From: Michael Eastham
Sent: 12 February 2019 11:51
To: Planning.Responses
Subject: FW: Planning Consultation on WA/116/18/DOC

APPLICATION NO: WA/116/18/DOC

Site Address: Land east of Tye Lane Walberton Arun

Description of Works: Approval of details reserved by condition imposed under ref WA/44/17/OUT relating to Condition No 6 Constructiion Management Plan and Condition No 14 construction compound.

- KEY:
- SITE BOUNDARY
 - GATEMAN AND WHEEL WASH ONCE ROAD CONSTRUCTED. ROAD BRUSH TO REPLACE WHEEL WASH.
 - COMPOUND, OFFICES/WELFARE
 - WASTE/RECYCLING AREA
 - BRICK/BLOCK STORAGE
 - CAR PARK
 - TYPE 1 PEDESTRIAN WALKWAY

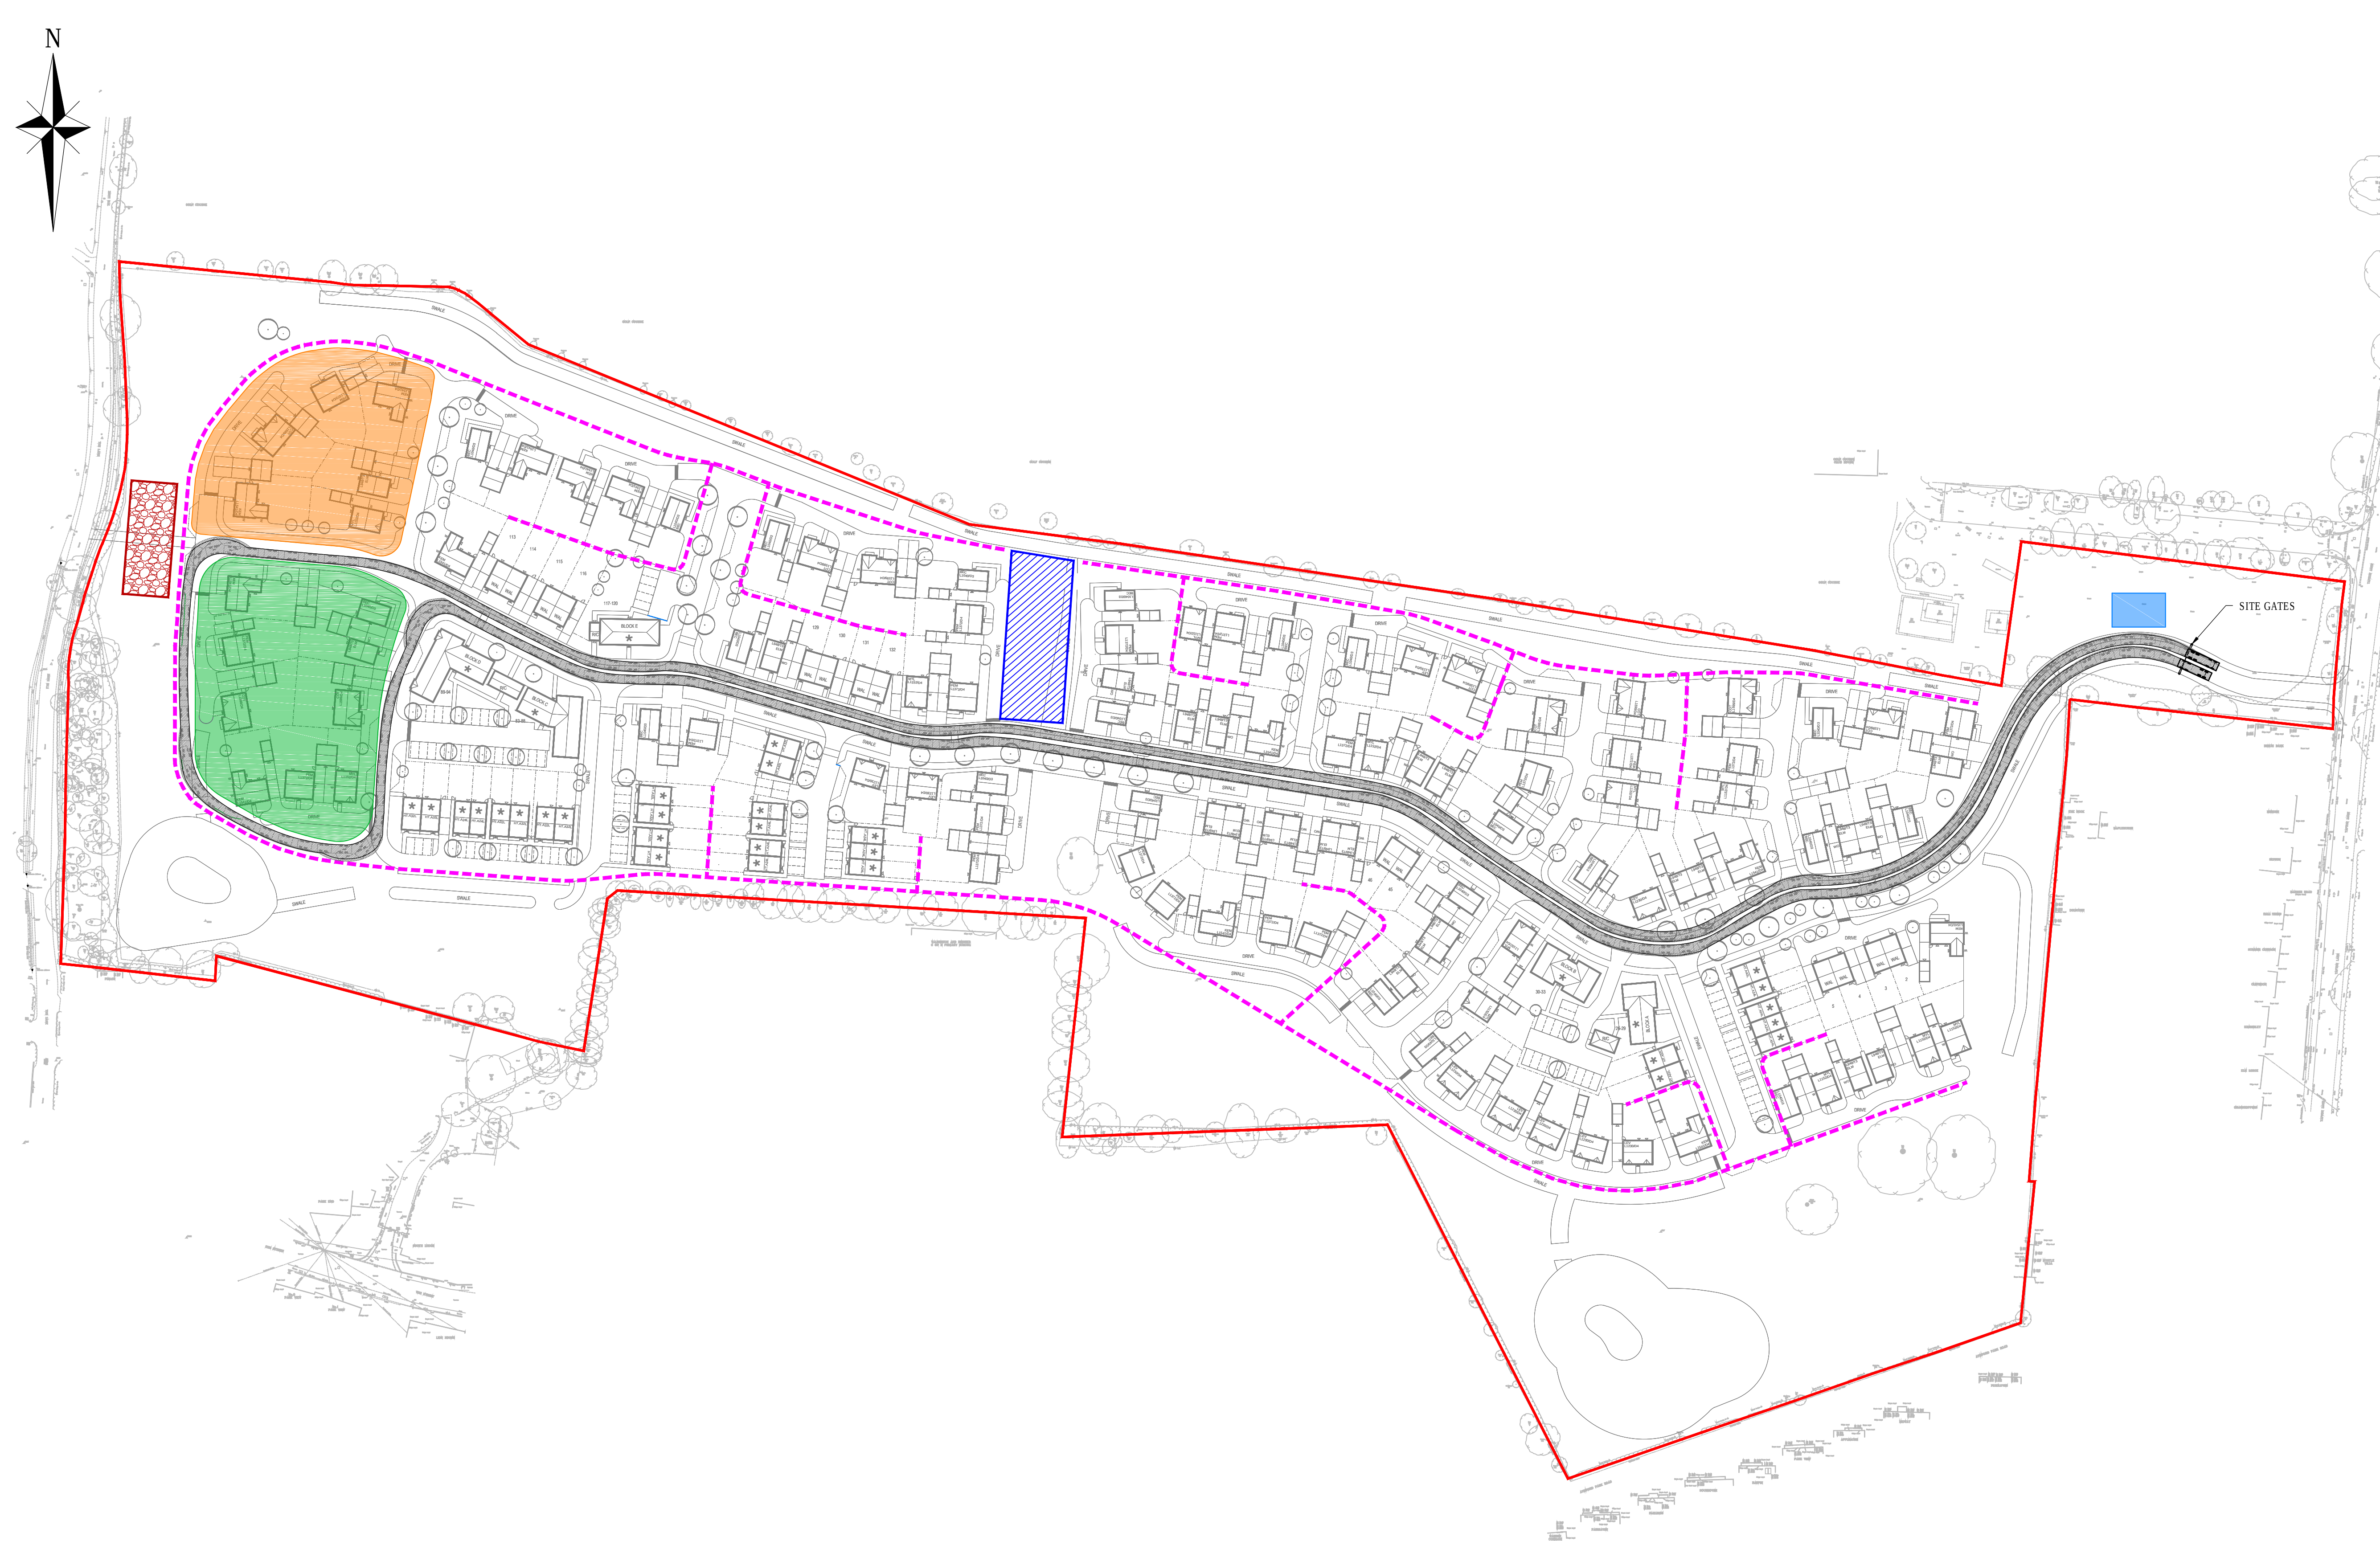
In relation to the wording of condition 6, I cannot find information on either wheel washing (although damping down is mentioned) or floodlighting. Please advise where these points are covered.

- Paragraph 3.3 and 4.39 - updated to refer to ADC.
- Paragraph 4.2 – Site contact details will be located on the site hoardings.
- Paragraph 4.38 – Sections A and B updated to clarify the type of equipment.
- Floodlighting – none is proposed.
- Wheel washing – details of how this will be managed is set out in paragraph 5.6.

location of the wheel washing facility is provided within an indicative site set up plan within **ACE Drawing 183240-009**.
